Q1.6.38. Sansoms Platt (SM)

In response to Historic England's concern over Sansoms Platt ( a scheduled Historic Monument) the developer states:  
" The Applicant considers that the heritage significance of the Scheduled Monument would be barely affected.....however, elements of the project would be visible...."

Title
Illustrative Masterplan
Figure 5.2
 Cable Corridor Plan Overview -
 Northern Site between the Oxfordshire
 Way, and B4027, south east of Wootton

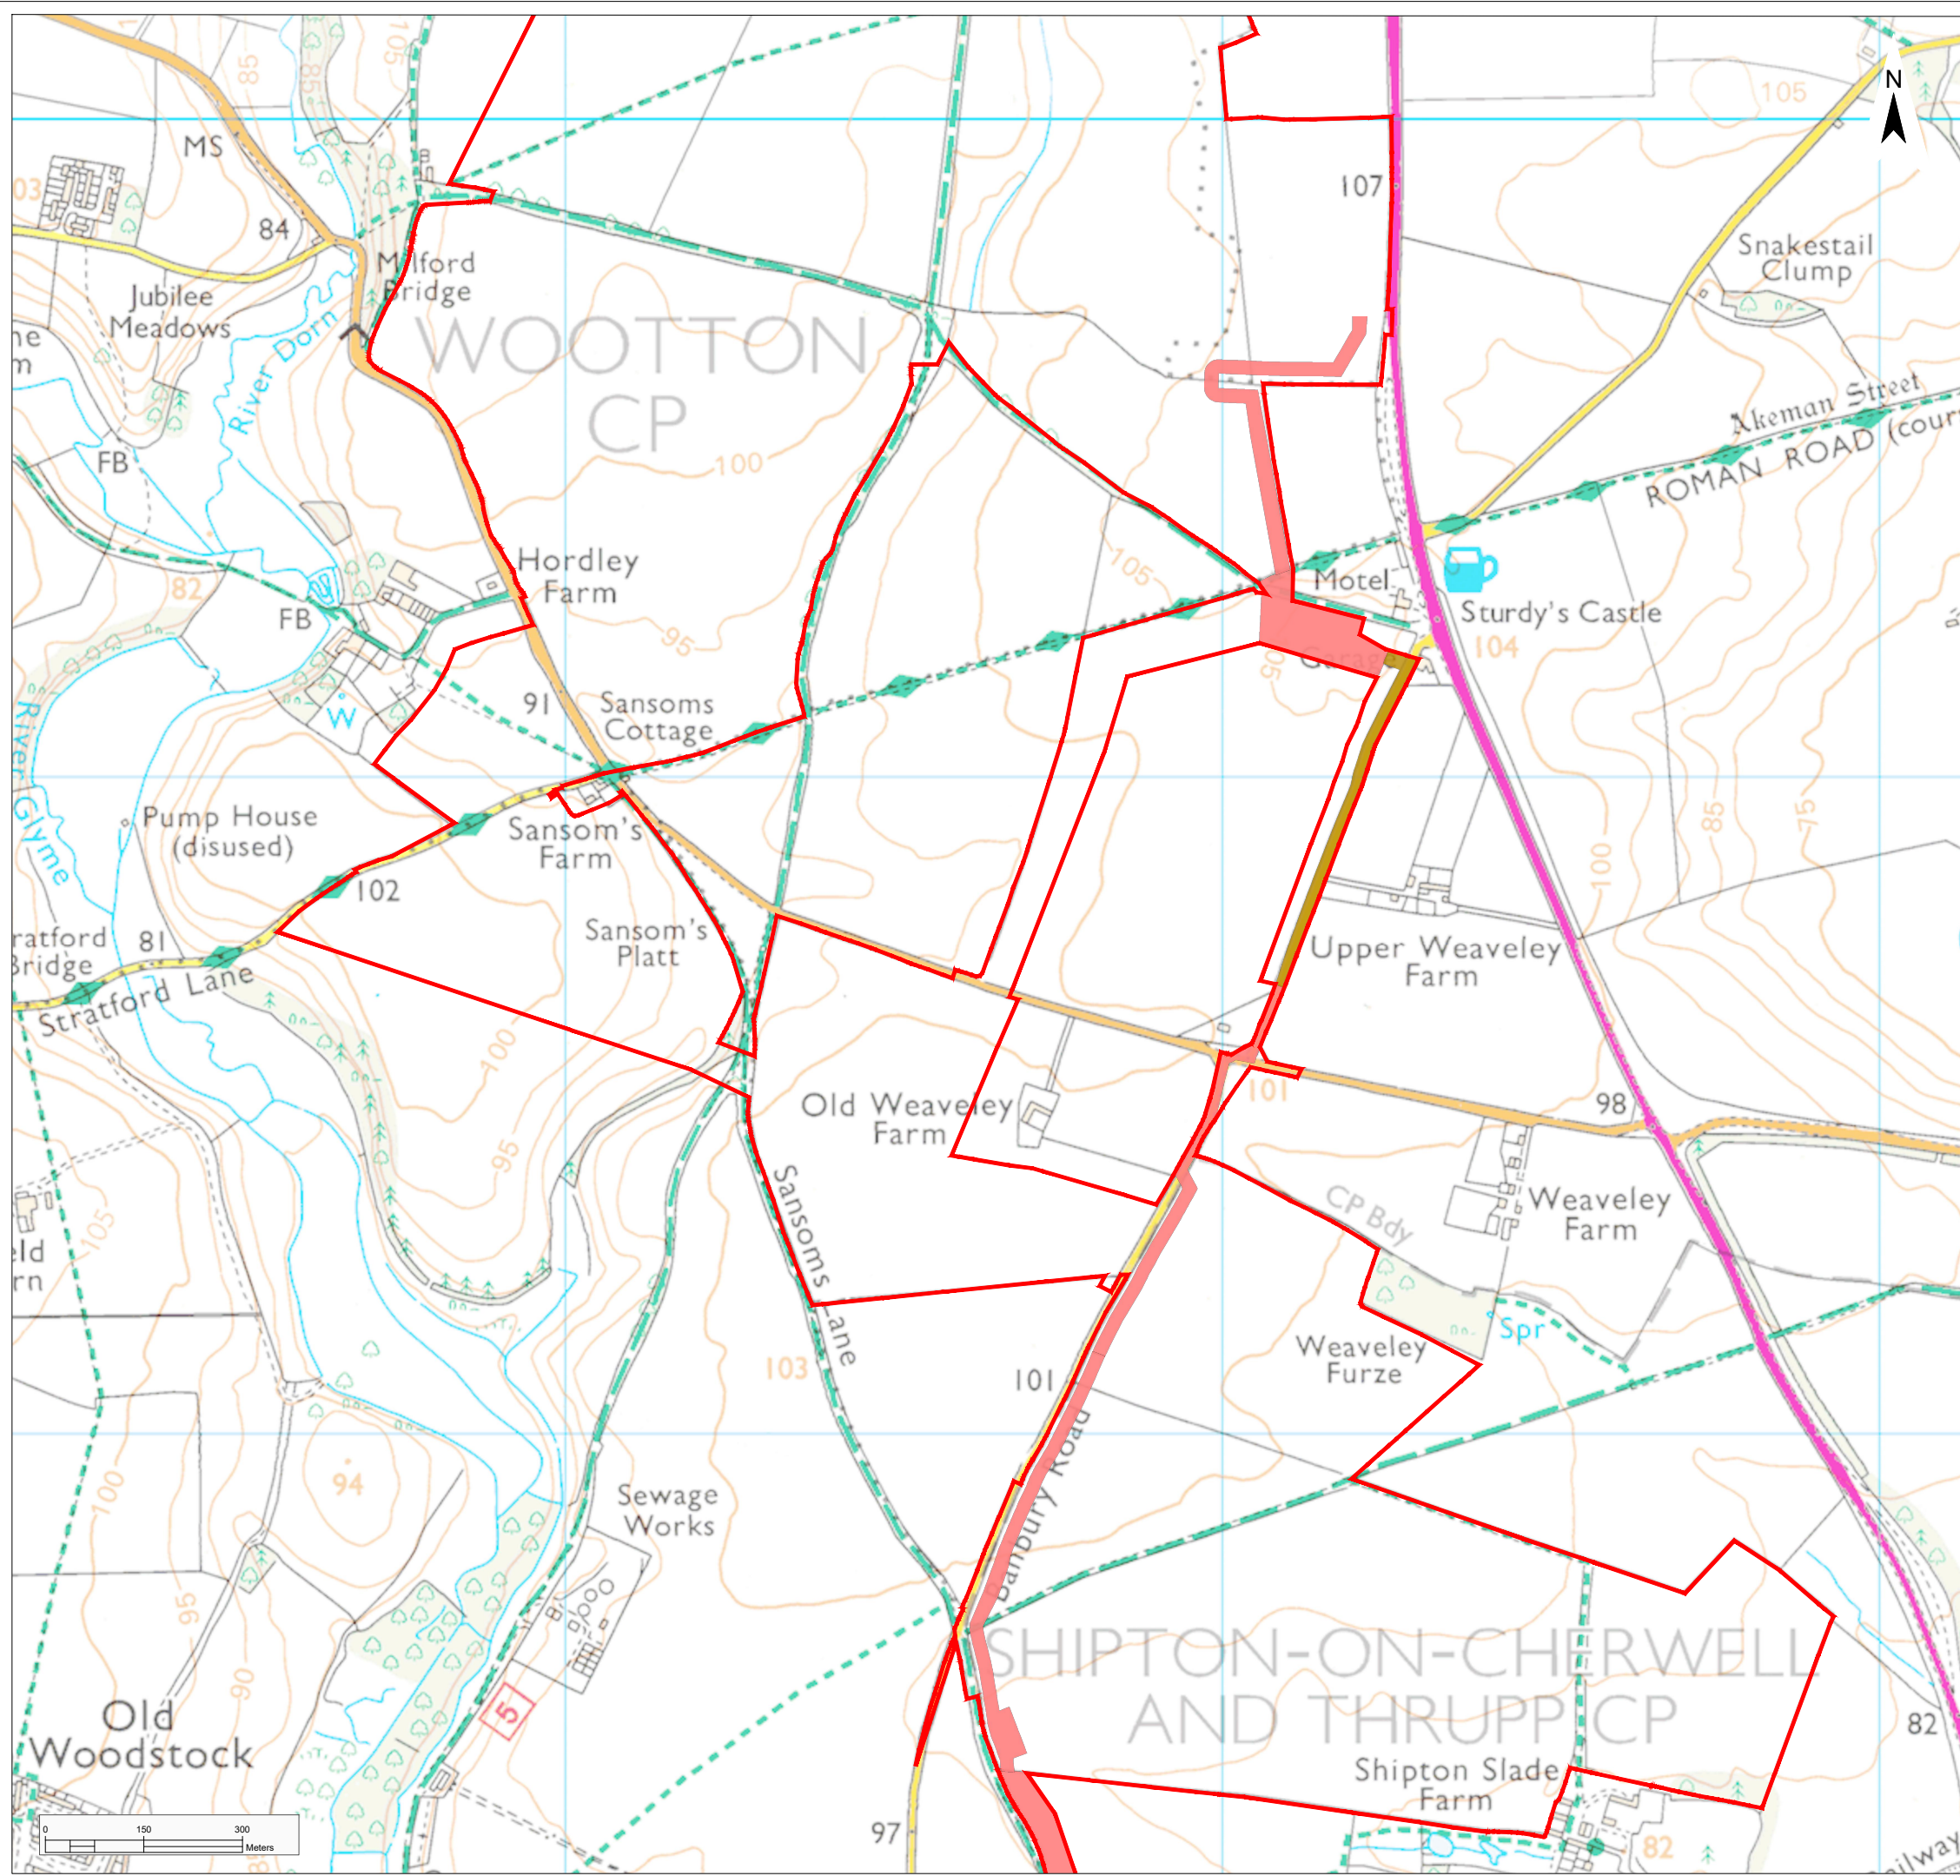
Q1.6.42: I also note there is a proposed cable run to be dug into the Drover's Path from the Dornford Area downwards and alongside field 1.11

As it is now proven that either side of this path contains more of the Roman Town than is currently protected and the developer is acknowledging this area's Roman remains by pulling back from The Platt. It makes no sense to protect either side of this path yet allow this path to be dug up, since it runs, like Akeman Street, through the town.

Neither should work be carried out on the section of Akeman Street running past Sansoms Cottage since, similarly, this pathway / Roman Road runs through the protected and unprotected area of the town. I reference the developers acknowledgement "Key features for the Roman period includes the important military road known as Akeman Street which crosses the Northern Site." 7.6.26

I call for this cable route to be stopped.
